## **LATE SCOPING CONSULTATION RESPONSES**

**Application by Highways Agency for an Order Granting Development Consent for the A14 Cambridge-Huntingdon Scheme. Scoping Consultation TR010018**

### **Application by Highways Agency for an Order Granting Development Consent for the A14 Cambridge-Huntingdon Scheme. Scoping Consultation TR010018**

Drawing file: TR010018 / TR010018-000625-A14 2.10 Traffic Regulation Measures Plan-CWL-Sheet 17 of 36.pdf

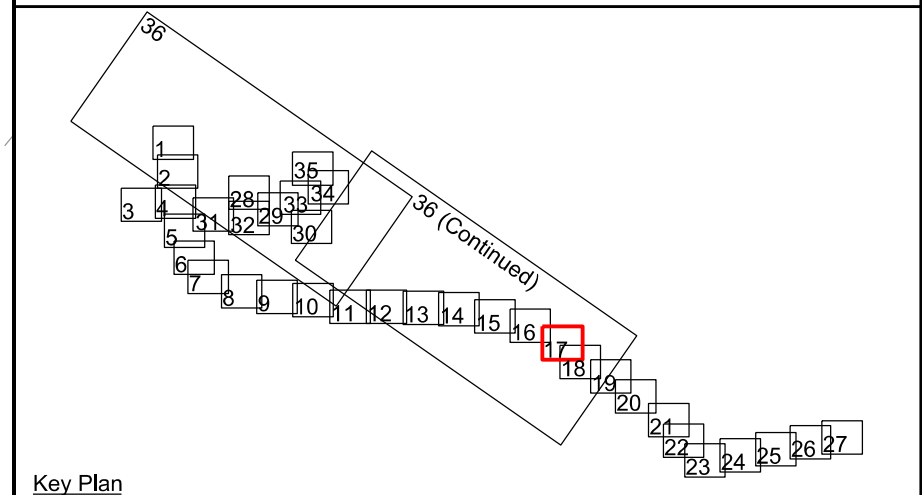
The Highways Agency should review the NMU route – it is circuitous and involves too many gradients – cyclists are unlikely to use this route and continue on the road instead.

There are approved plans for the Dominos site where the proposed 'potential replacement special category land' infringes on the approved built footprint of the development.
